OUT15/34461

**Rix's Creek Mine Extension Project (SSD_6300)
Response to exhibition of Environmental Impact Statement**

Rix's Creek Extension project (SSD 13_6300) Response to exhibition of Environmental Impact Statement DPI Water – Detailed Comments

Flux vs. Time at Pit 3 (Drain Reach 53)

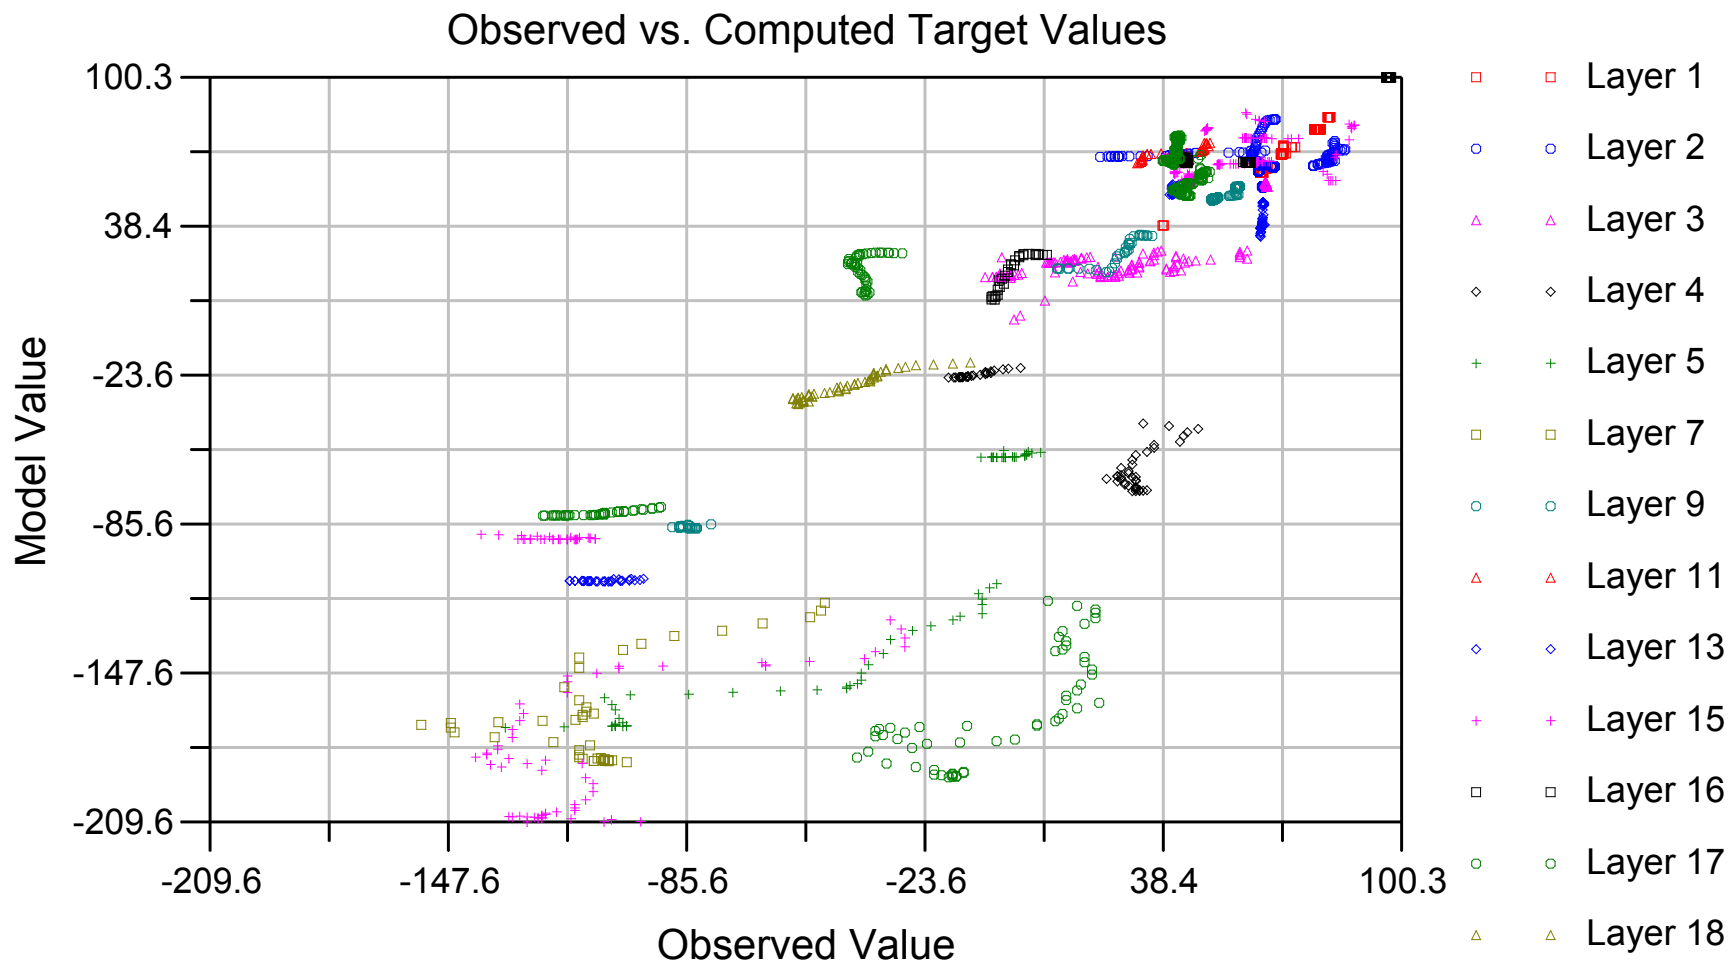
13. There is uncertainty why the model experiences such instantaneous, rapid increases and declines in inflows into the pits as shown in Figures 8.11; 8-16 and 9.1 and discussed in Sections 8.7.3; 8.8.2 and 9.2.1 respectively. Clarification is sought from the proponent to show that these artefacts are indeed related to the progressive implementation of the mine plan, pit development and back filling and are not related to model instability.

CALIBRATION MODEL – MODELLLED GROUNDWATER LEVELS VERSUS OBSERVED FIGURE 8.13

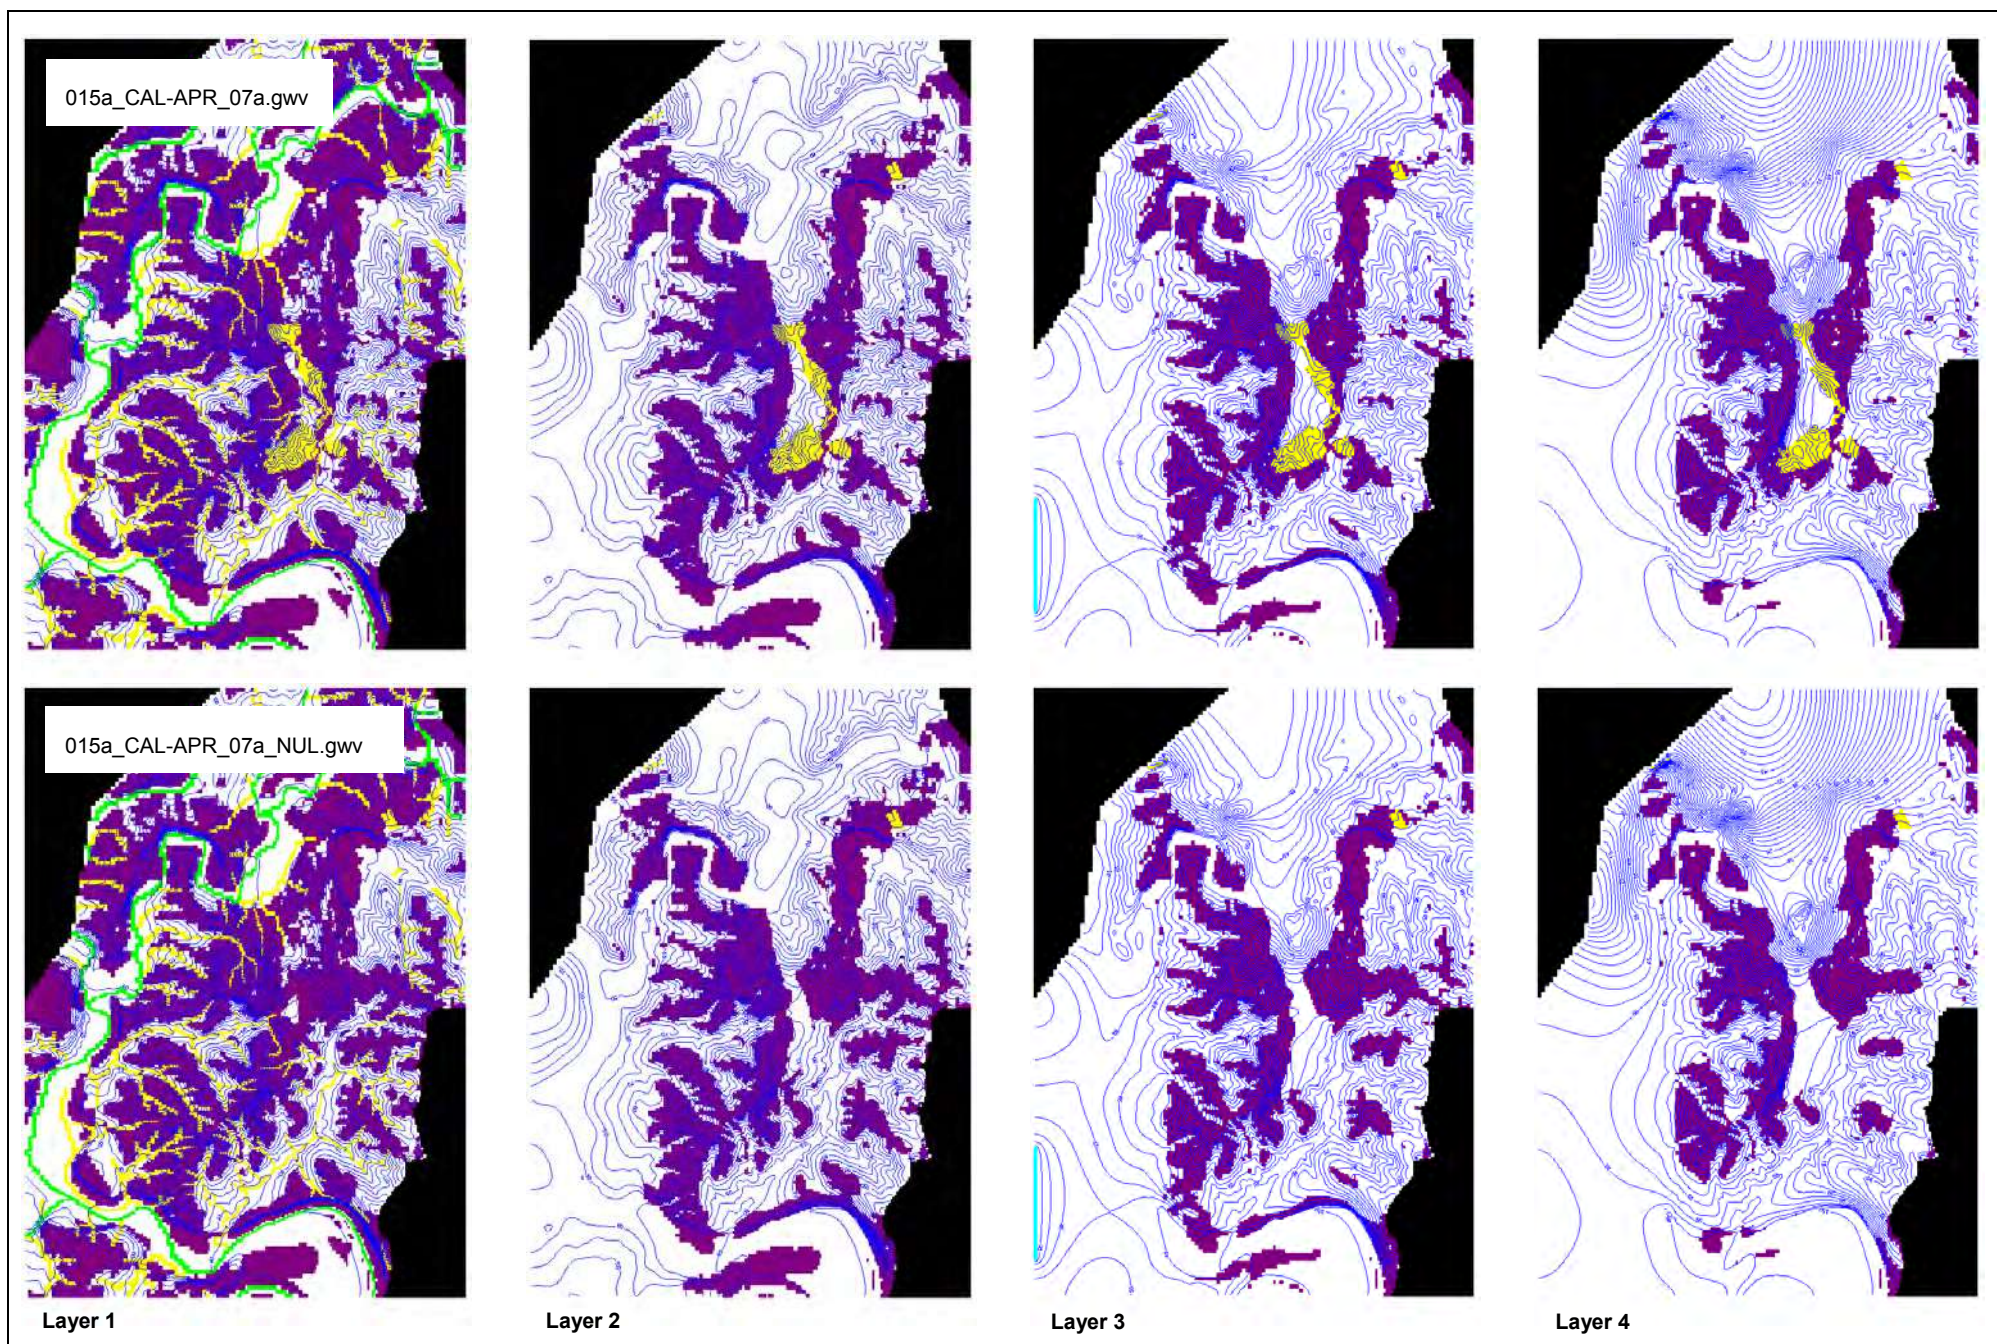
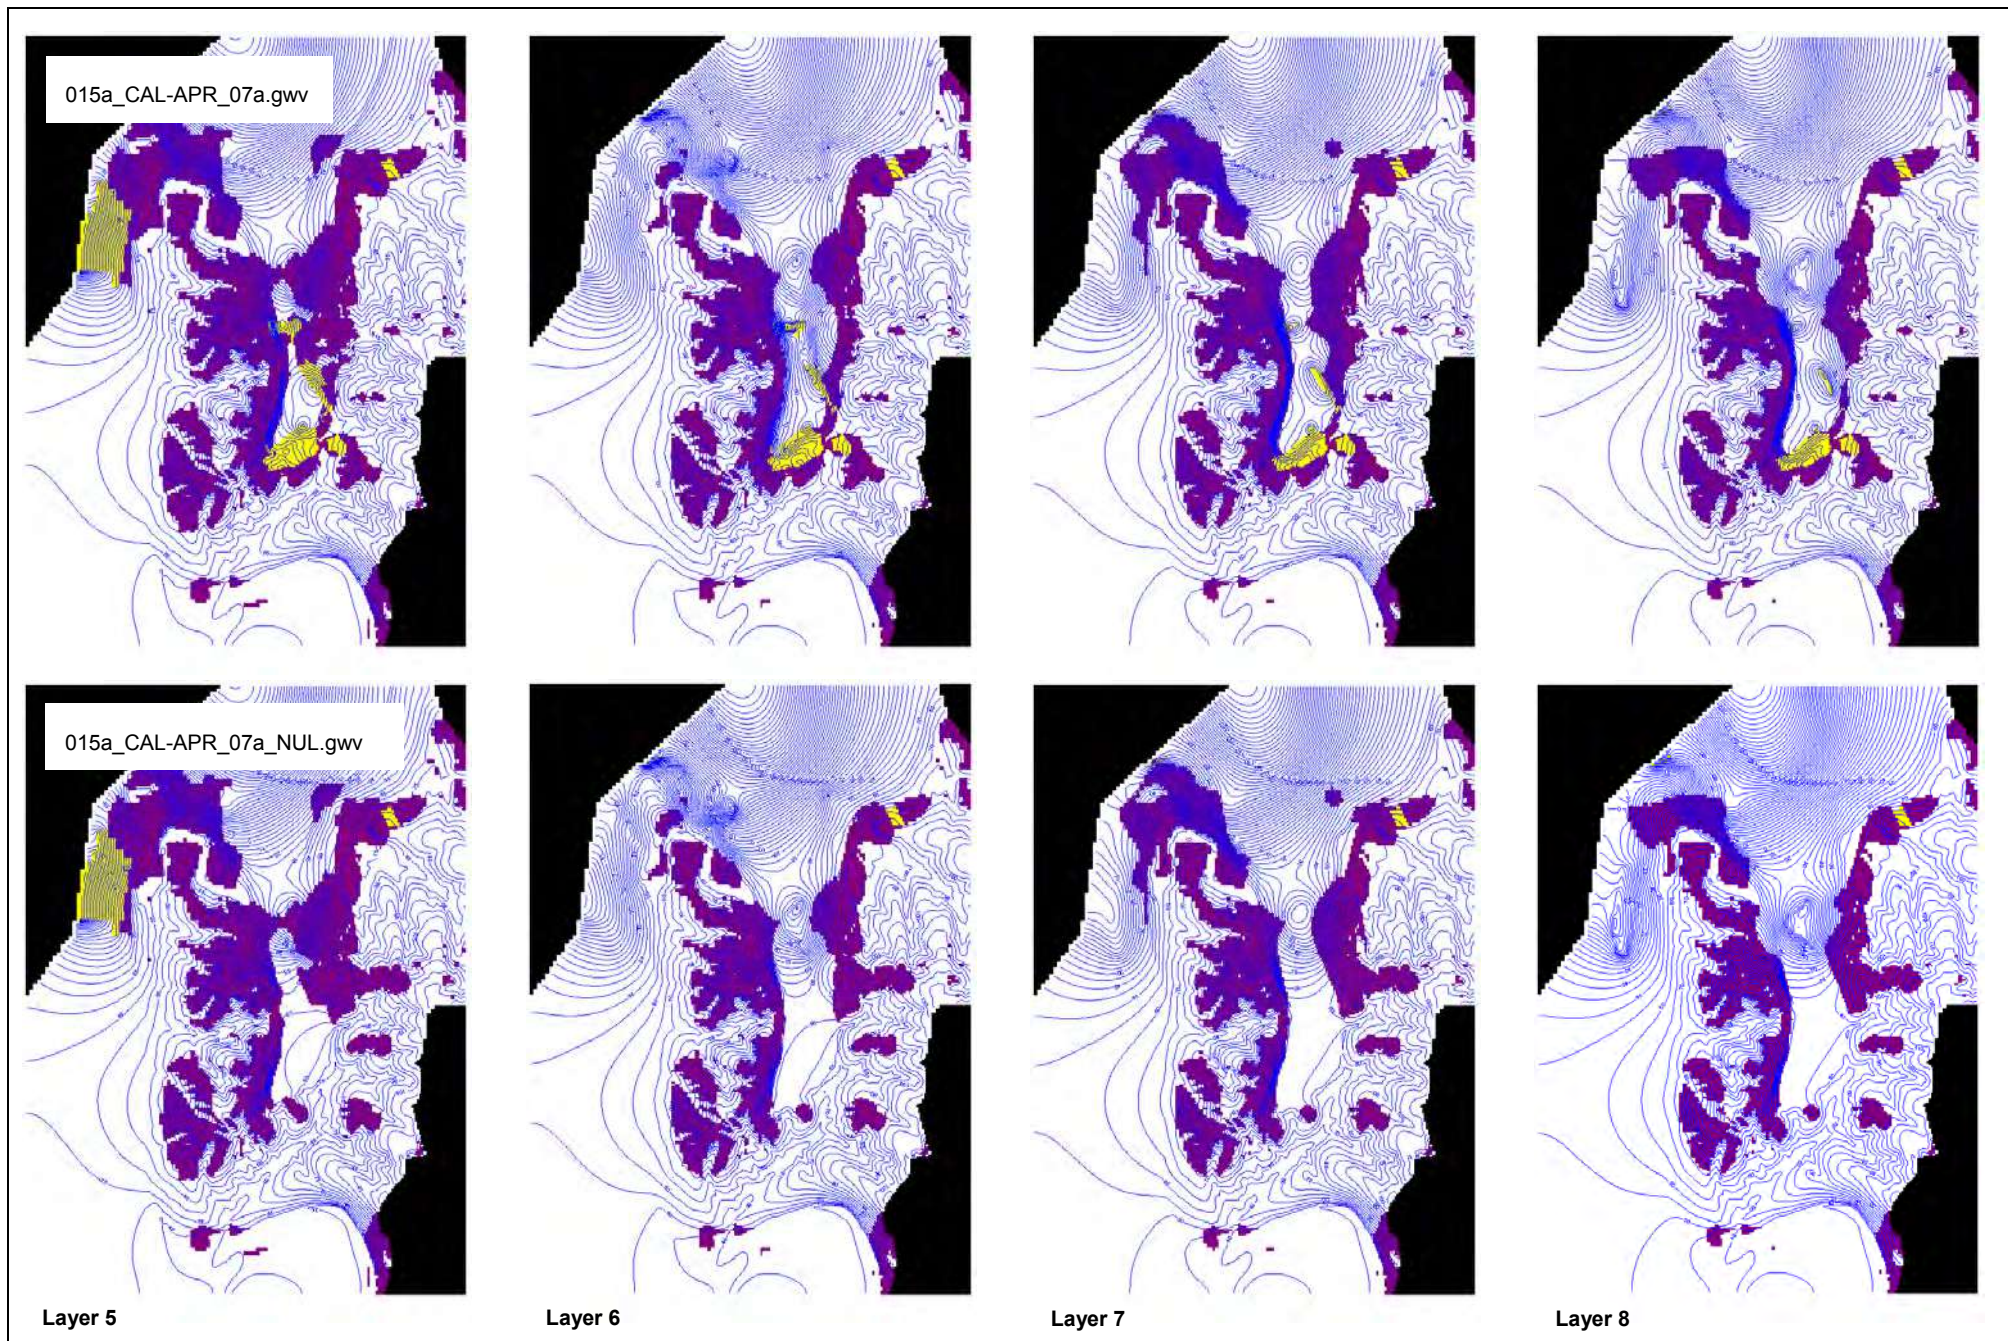
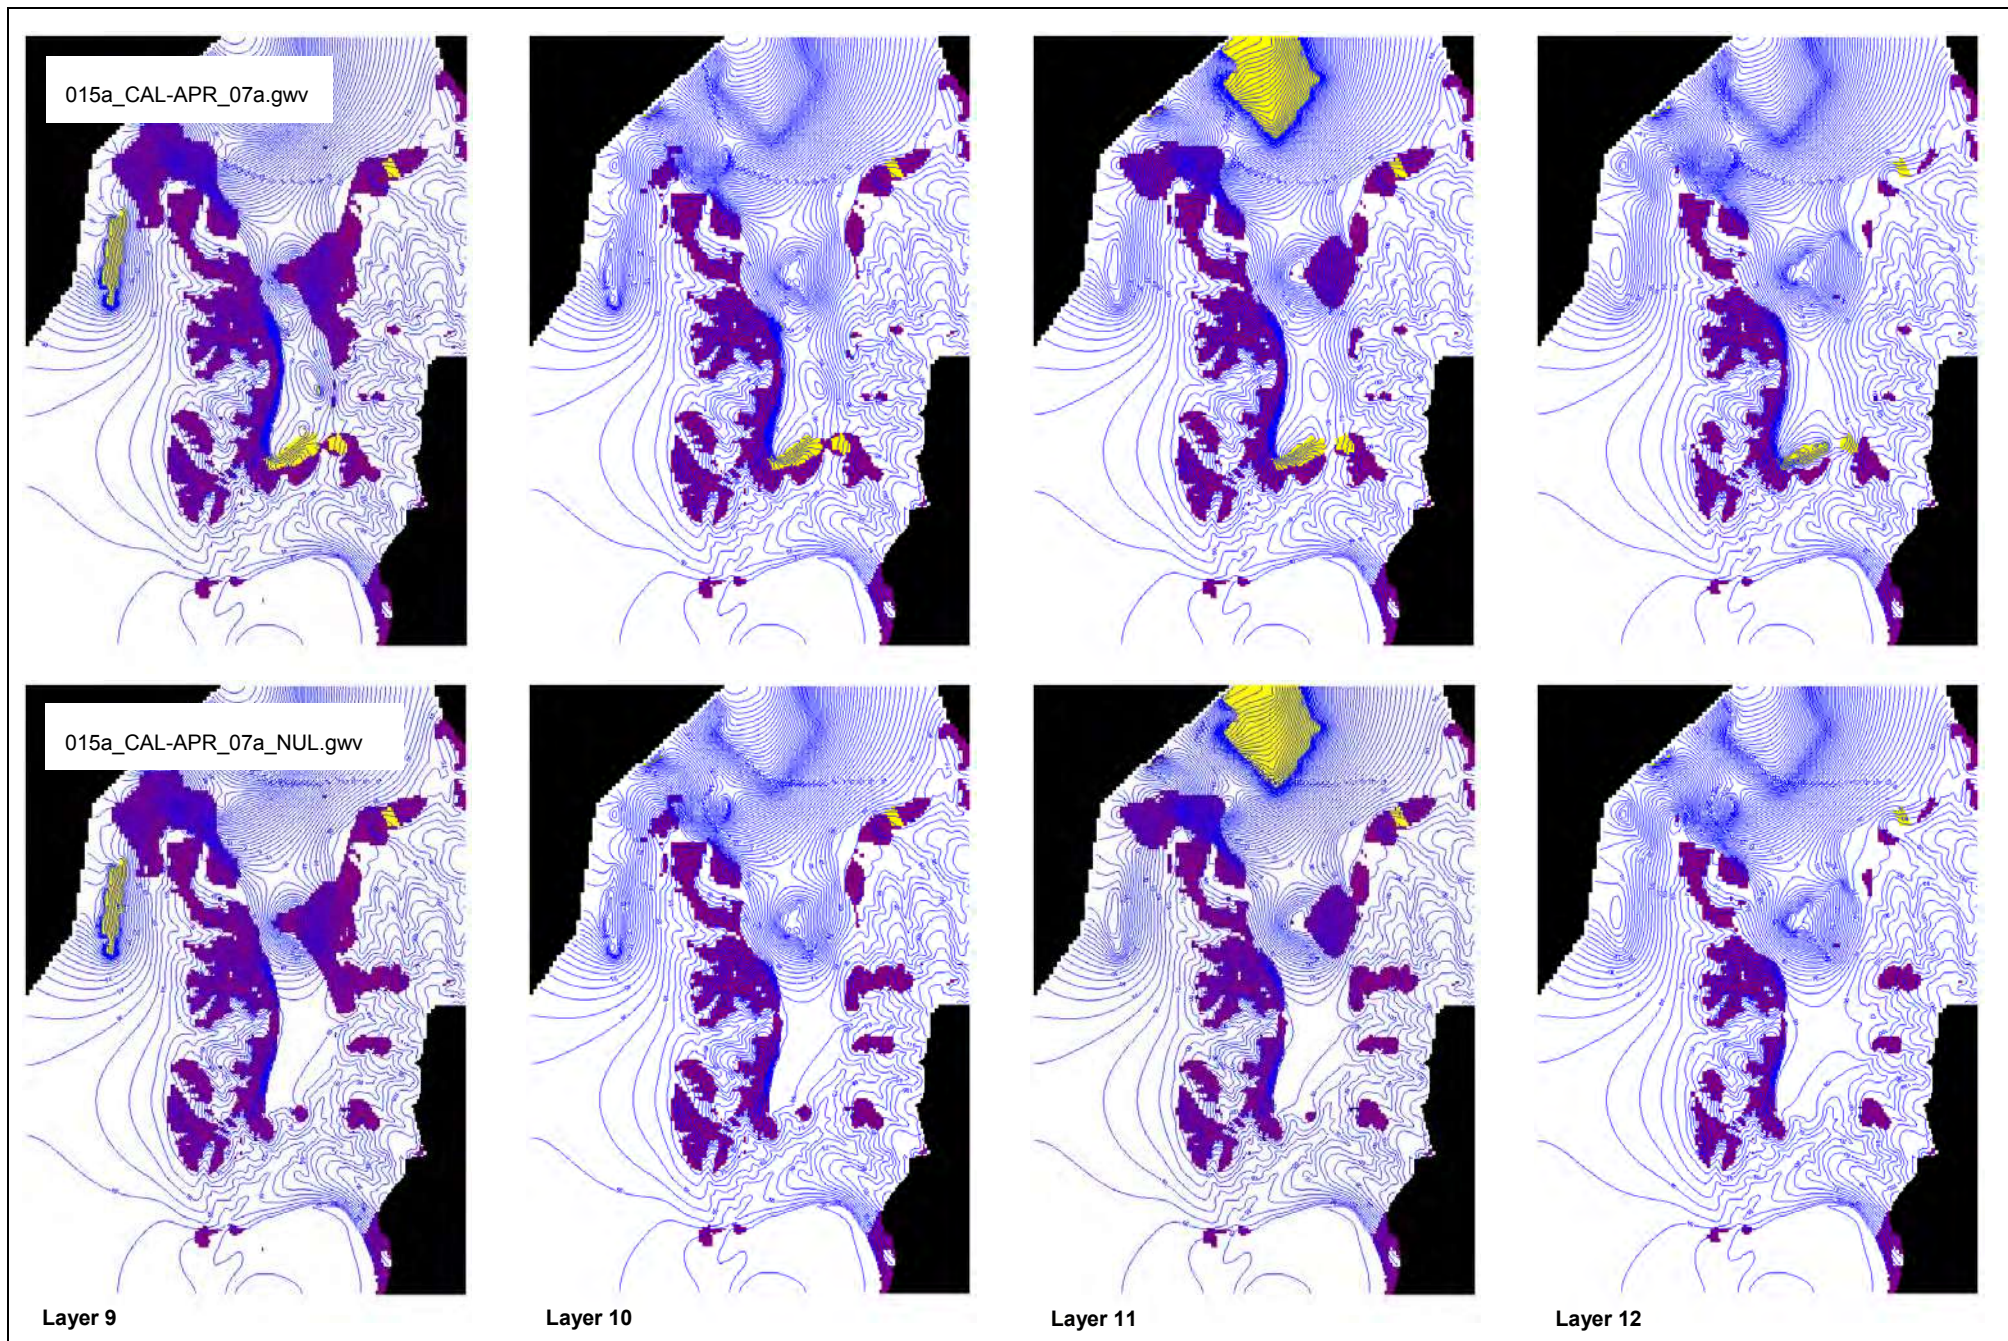
2. The model was not calibrated. A scaled root mean squared error (SRMS) of 16% was achieved. The Australian Groundwater Modelling Guideline recommends ~10%. The calibration hydrographs were not legible so no analysis of the calibration was performed by DPI Water.

8. The calibration dataset type should be better described and it is unclear where the calibration points are situated as no legible map has been provided.
